1st February, 2011

Tree Retention – Stage One Putney Green Residential Development, Putney, NSW.

Further to our recent site meetings and discussions relating to the potential to retain trees, I have reviewed the plan 3025.TR01, dated February 2011, prepared by Environmental Partnership.

DWG NO.
 3025.TR01
 ISSUE
 6

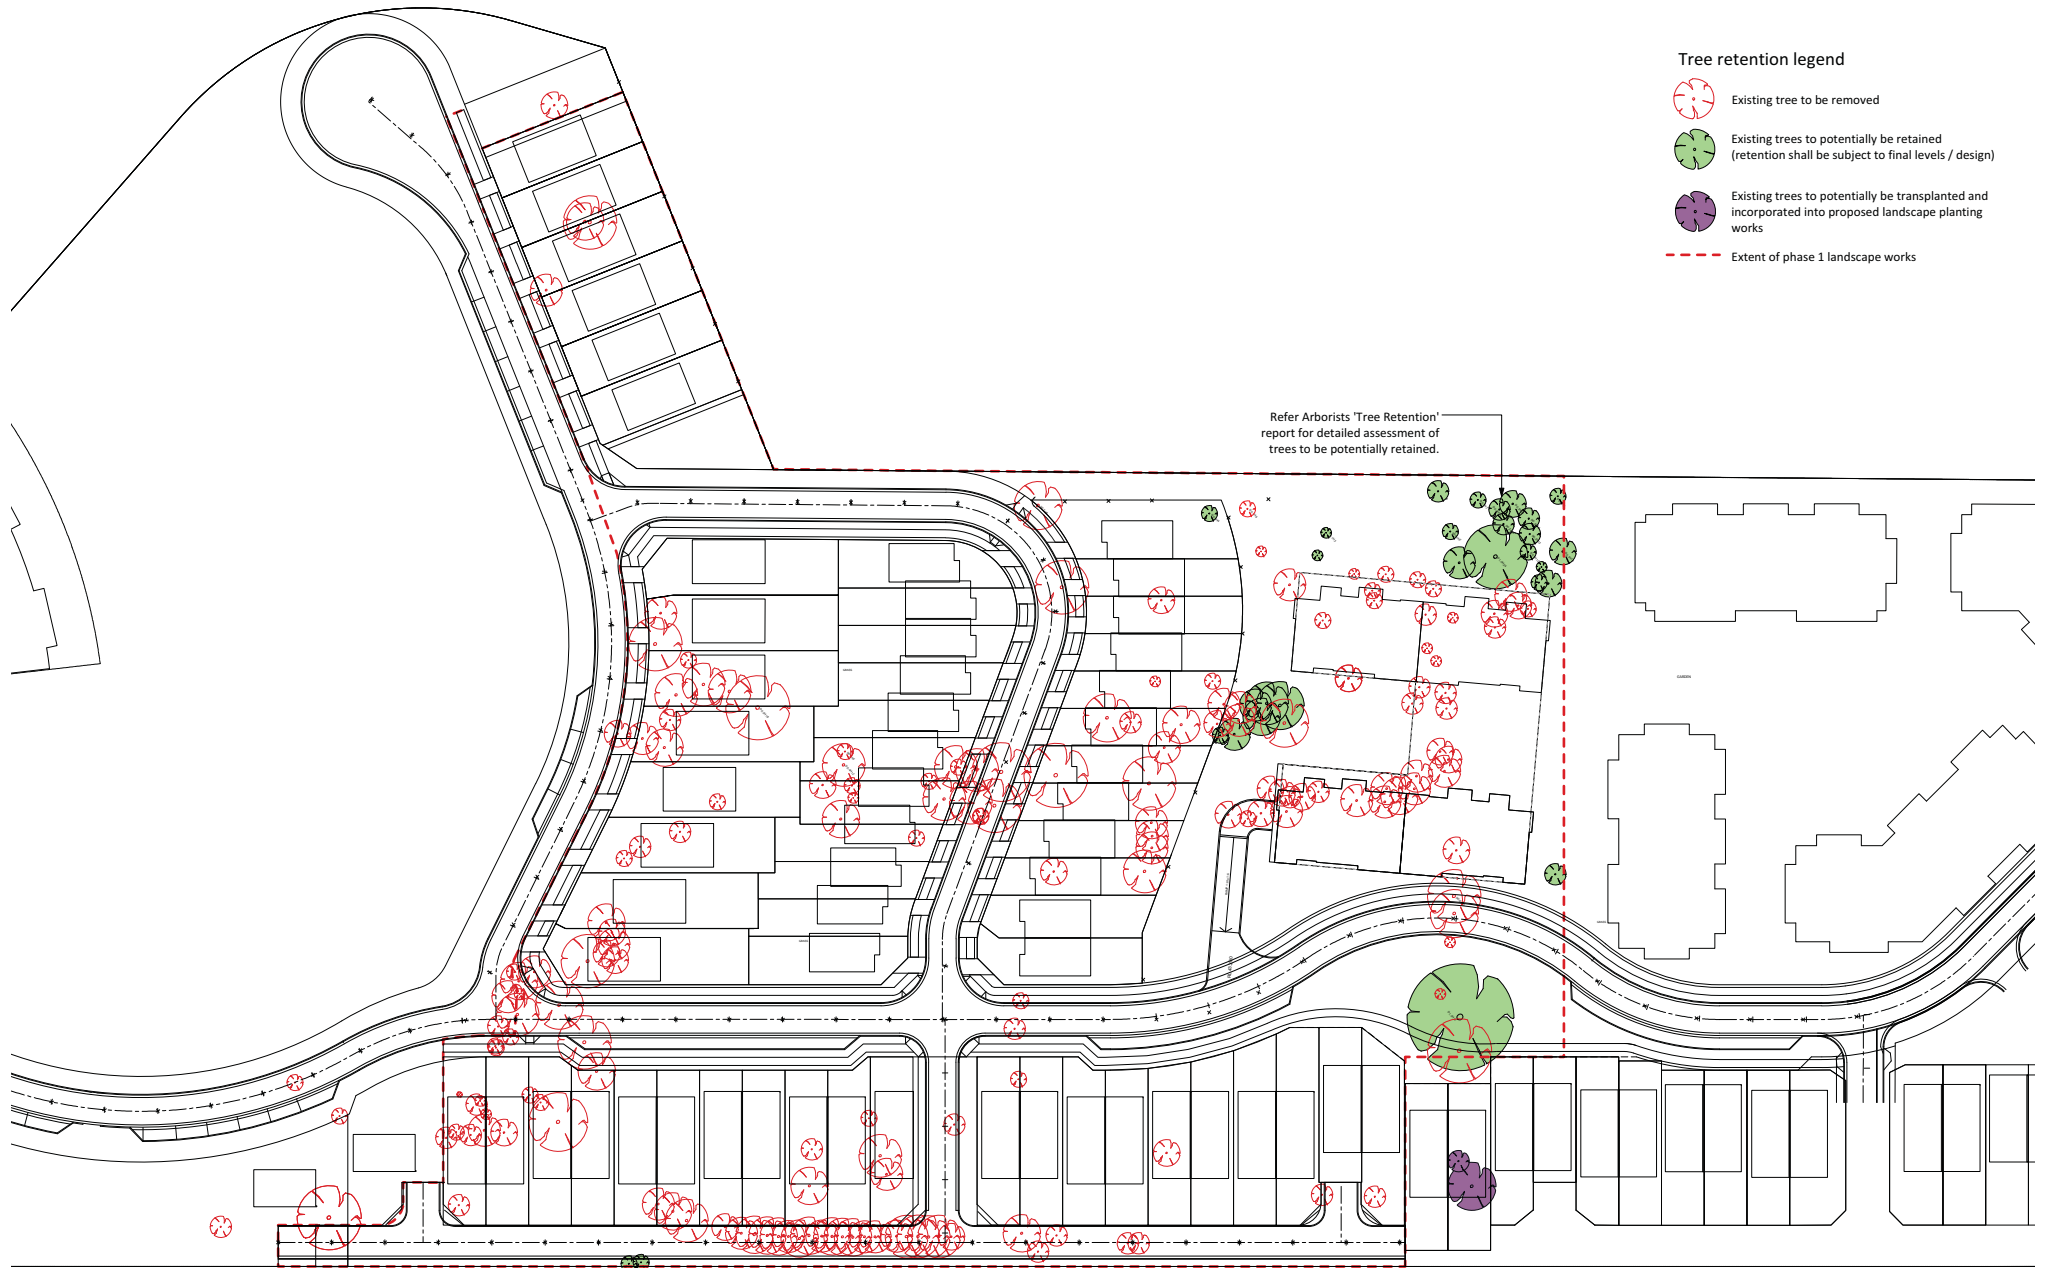
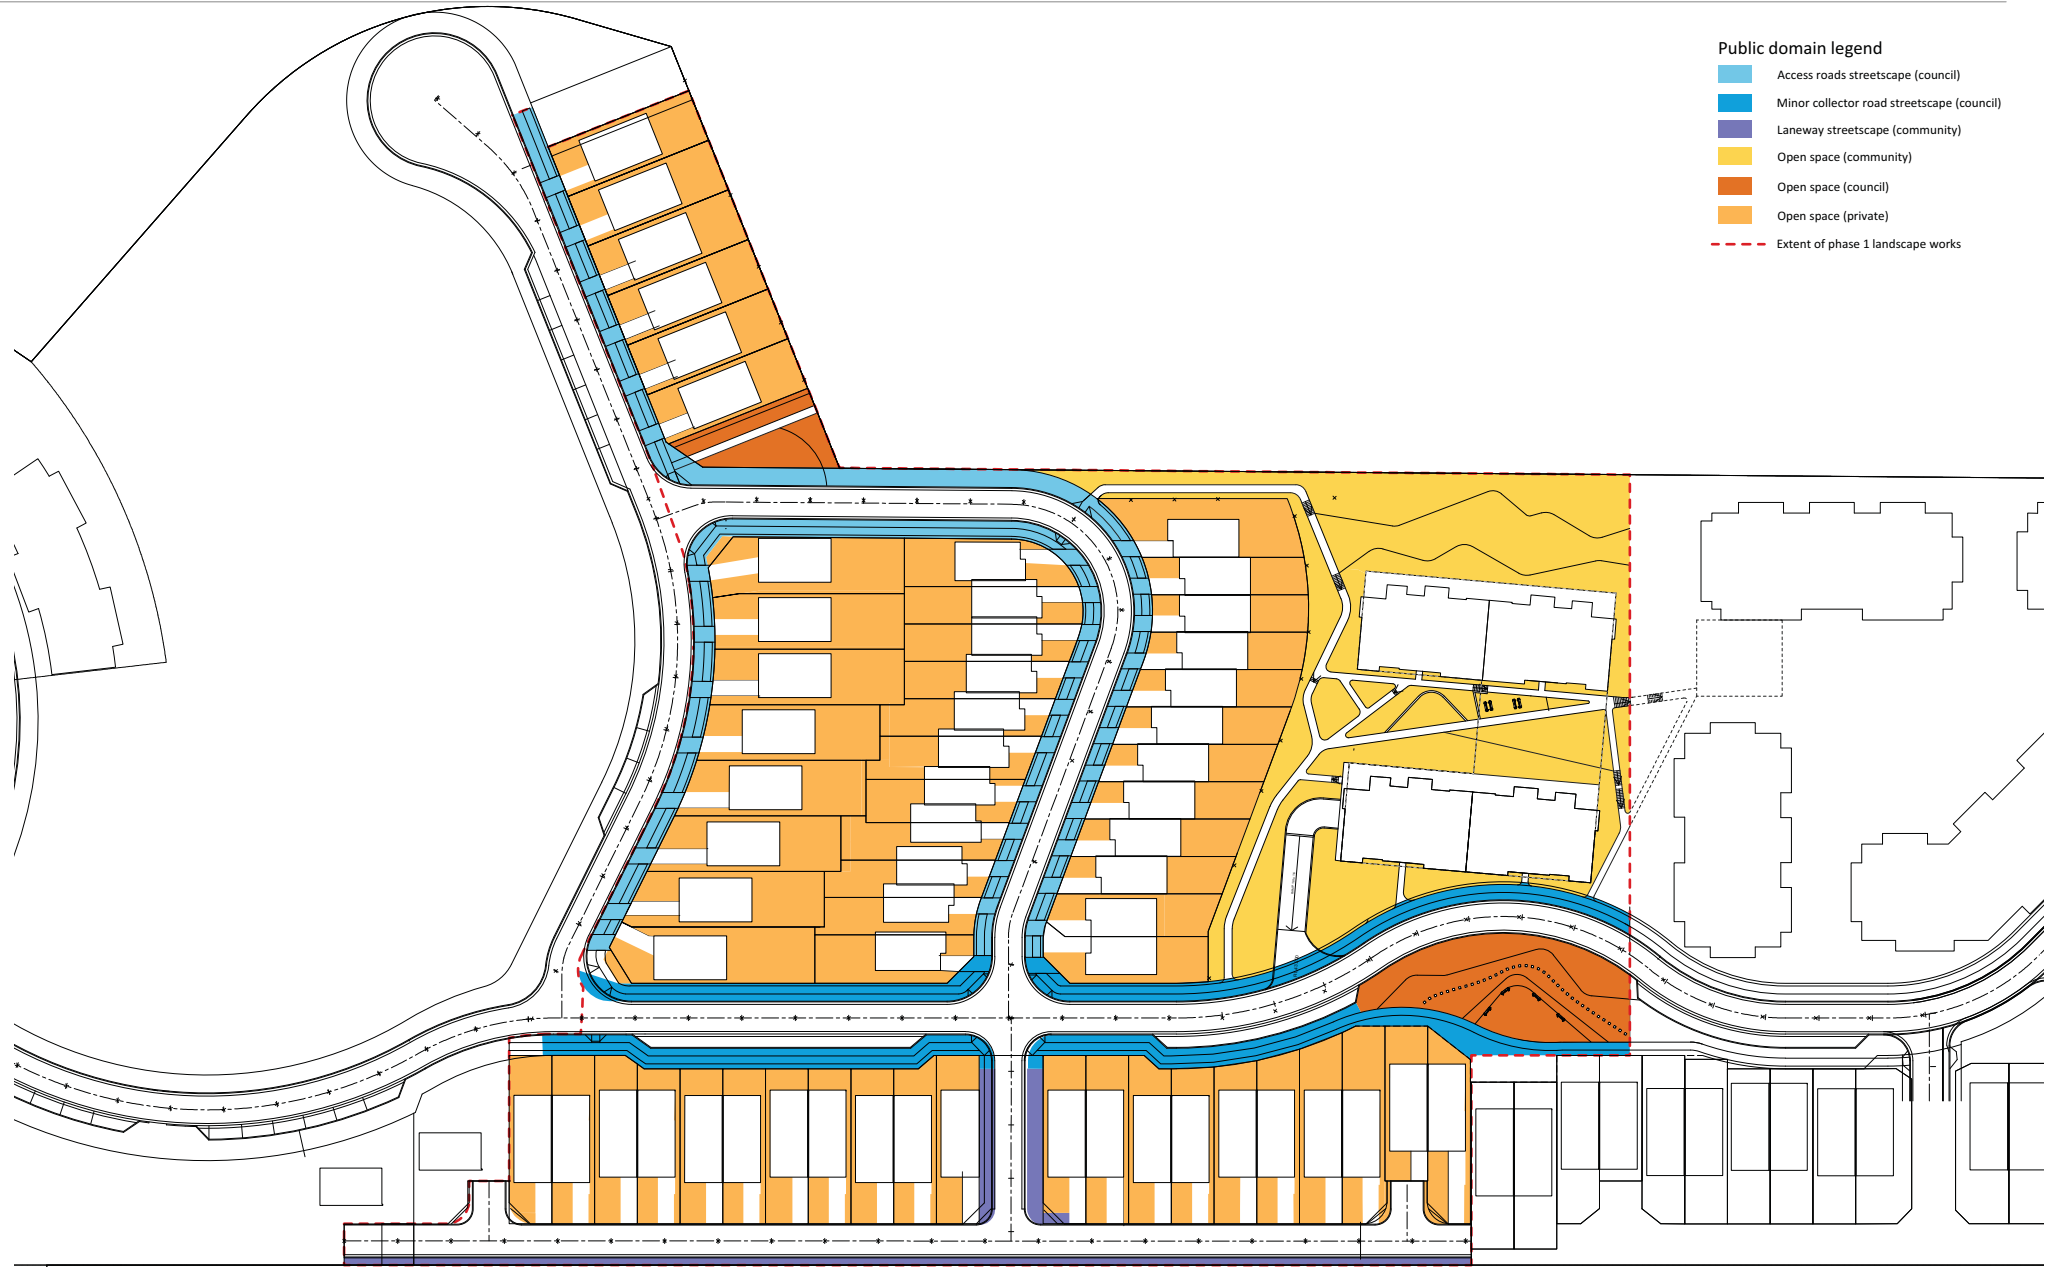
The tree could be retained, although this will require retention of all existing levels outside the proposed building footprint and within 10m of the tree in other directions. Excavation would occur outside the tree's Structural Root Zone (SRZ), and is unlikely to have any impact on tree stability. The encroachment in to the tree's 7.8m TPZ is considered to be moderately high, and could affect tree health over the longer term. However, if protection of the remaining TPZ is given priority, the successful retention of the tree would be enhanced. This protection could include modification of the proposed building footprint to increase the distance of the building to around 10m from the tree, if this can be accommodated.

If this building footprint cannot be amended it is preferable to consider retaining the tree, rather than removing it on the basis that it may not tolerate the changes and go into decline. It is quite possible the tree will not exhibit appreciable changes to its vigour post-development.

The majority of this tree group (approximately 17 trees) can be retained, provided the existing ground levels are maintained within an appropriate distance from the trees. It appears this would be achievable given the space available around the tree group.

It is possible that 2 or 3 trees closest the proposed building may be affected by development. The potential for their retention would be assessed during finalising of design levels.

One tree from this group falls within the boundaries of Stage One. Retention of the tree is possible, subject to the final design levels accommodating the tree's protection zone.

Potentially, two of these three small trees could be retained. They are both very young Paperbarks (*Melaleuca* sp.)

Both of these trees are well clear of the proposed road and dwelling footprints. Retention of these trees appears to be readily achievable.

These two trees are large Hills' Weeping Figs. It is possible the trees could be transplanted and located elsewhere on the site. The potential for successful relocation will be dependant on detailed assessment of a transplant contractor to determine the suitability of the trees for transplanting.

Given their location clear of the proposed buildings, the retention potential of these small trees is high.

This is a pair of very young *Backhousia citridora* (Lemon Myrtle). The trees have not been located by survey on the plan, but are close to the boundary with adjoining properties. It is possible the trees could be retained, but this will be reliant on the final driveway levels, and whether they would result in unacceptable encroachment into their root zones. The trees are not significant in size or species (being introduced native and not endemic), and could be replaced with appropriate plantings at the landscaping stage of the development.
